KITTITAS COUNTY

MEMORANDUM

TO: Jeff Watson
FROM: Christina Wollman, Planner II *cw*
DATE: October 14, 2010
SUBJECT: Kittitas County Fire District #7 PF-10-00003

The Department of Public Works has reviewed the Public Facilities Permit for Fire District #7 and has the following comments:

PHASE I FS #78  
**SITE DEVELOPMENT PLAN**  
 1" = 30' - 0"

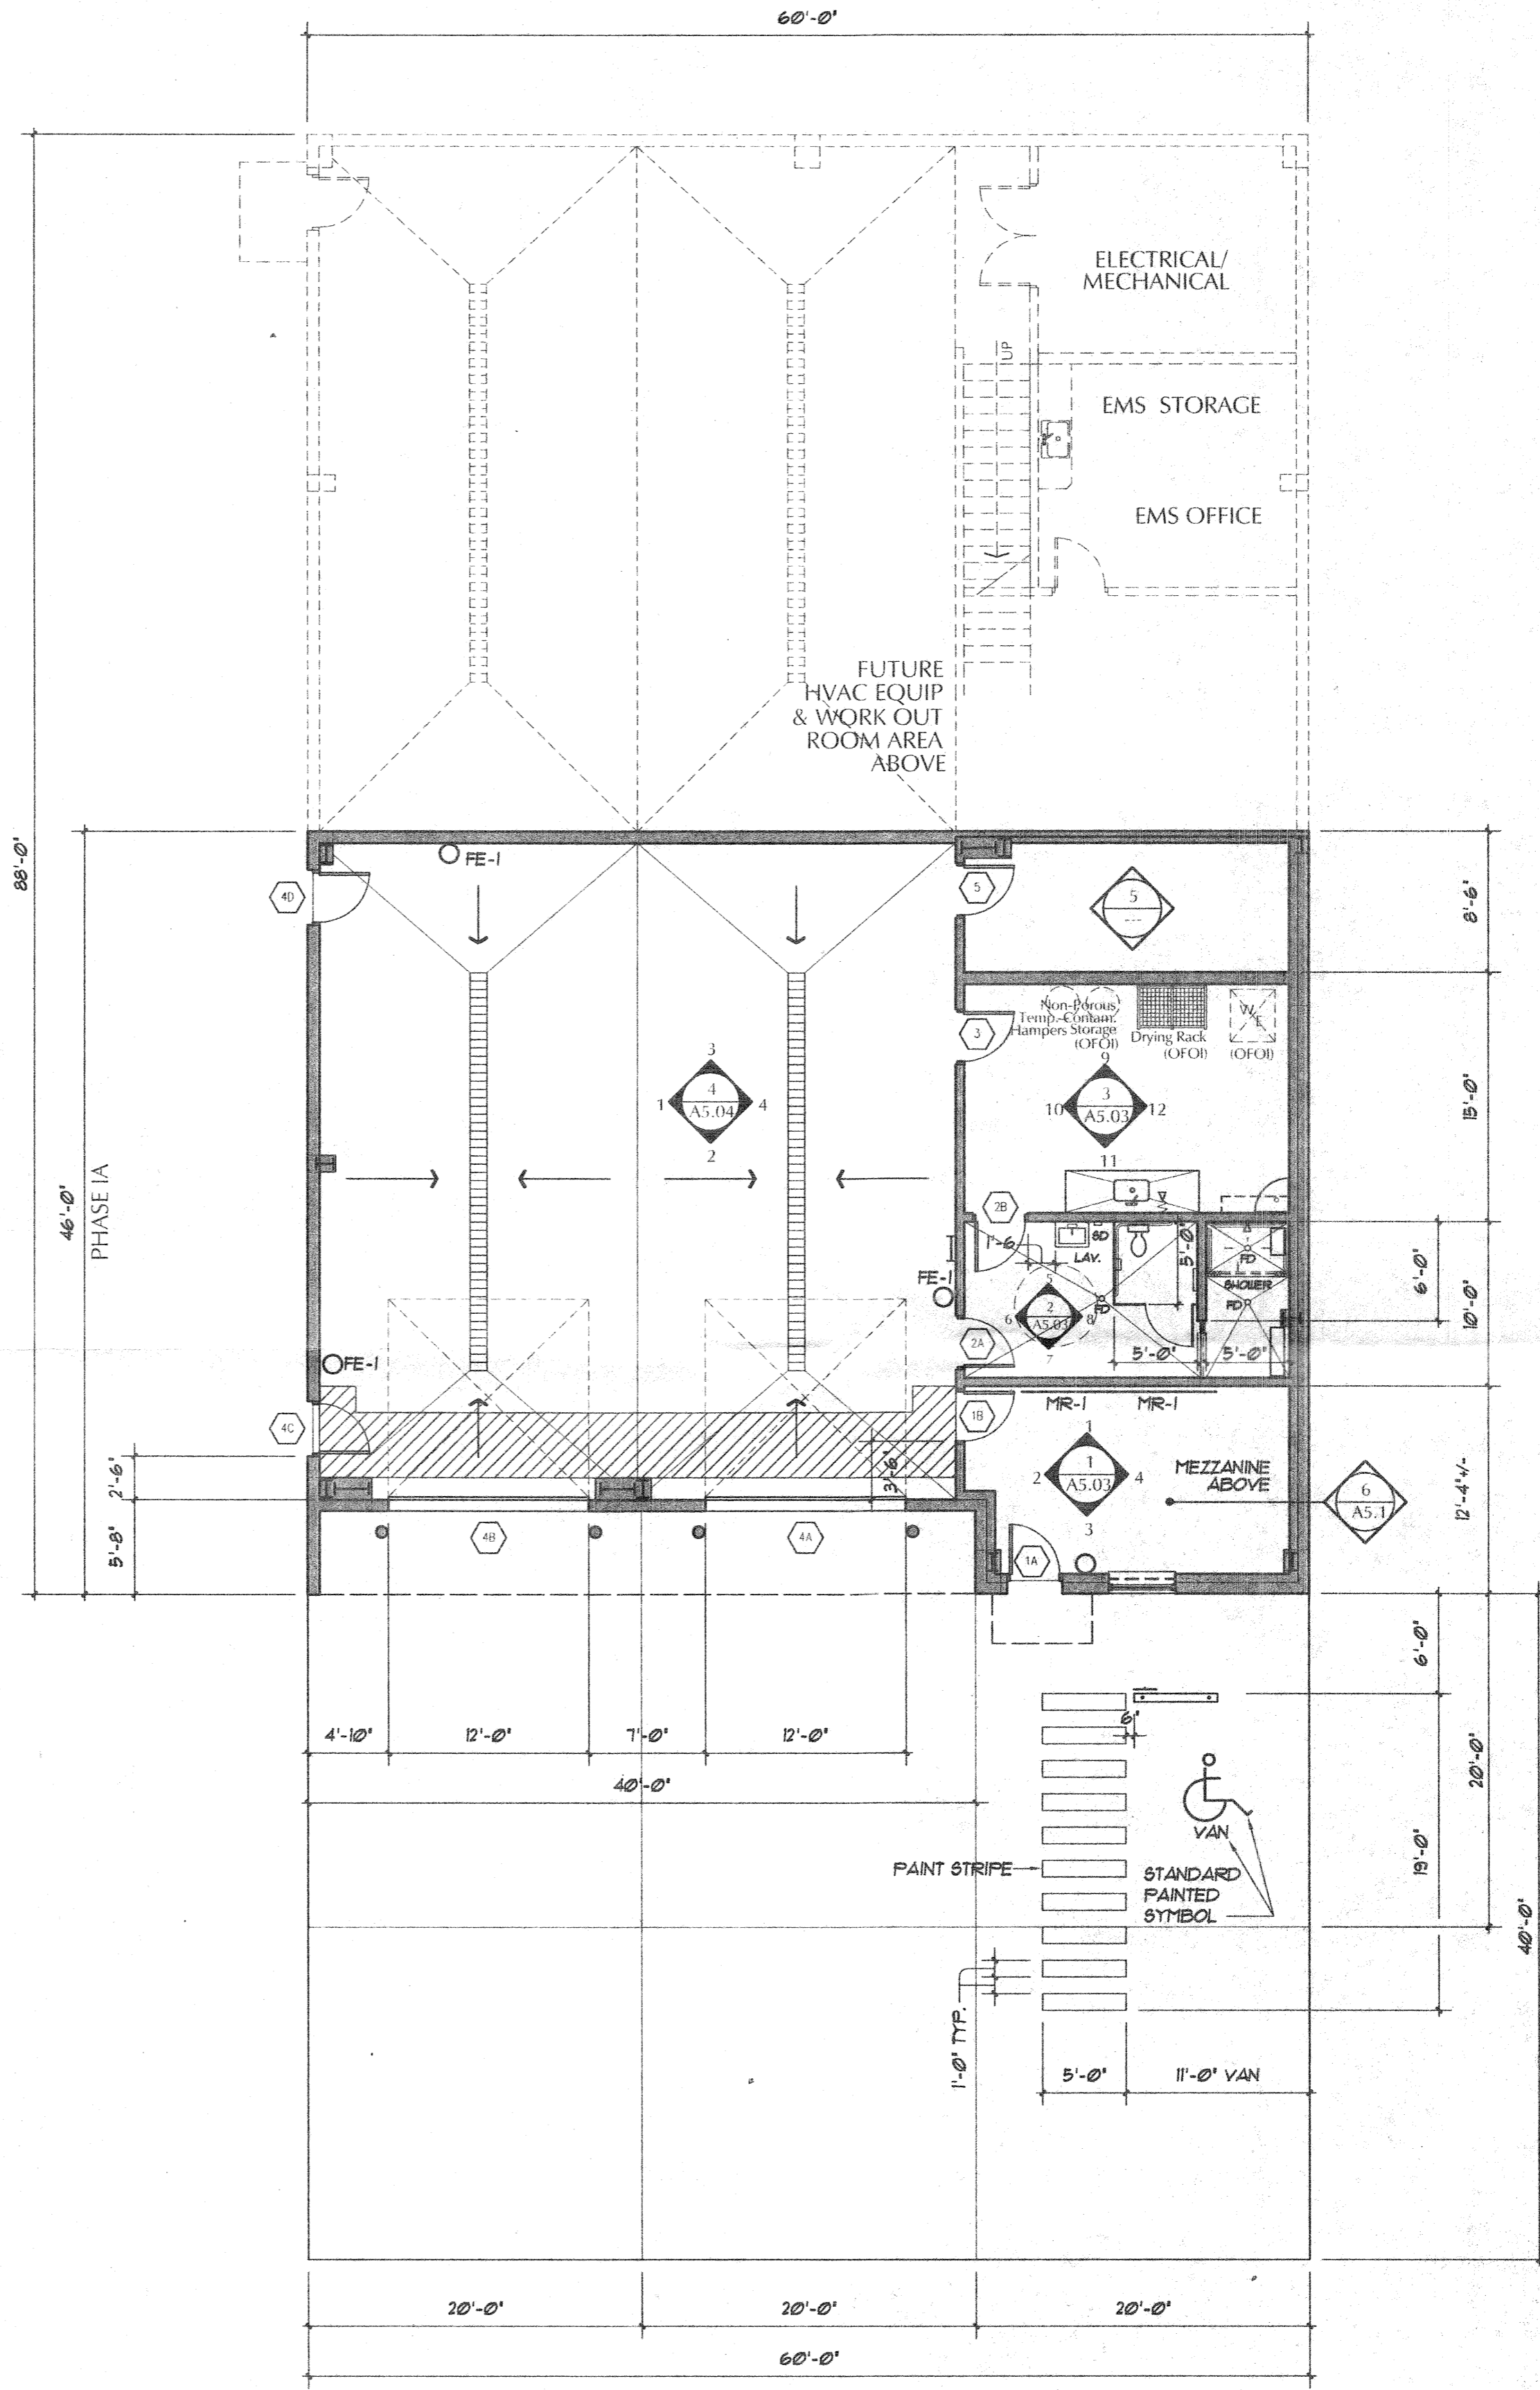
- A. An access location has been approved at 16660 Salmon La Sac Road. The approach is currently constructed to residential standards. With the construction of the fire station, the approach must be improved to meet commercial standards as shown in WSDOT Design Manual Exhibit 1340-5 (attached). Prior to performing any work within the county right-of-way, an access permit must be applied for from Public Works.
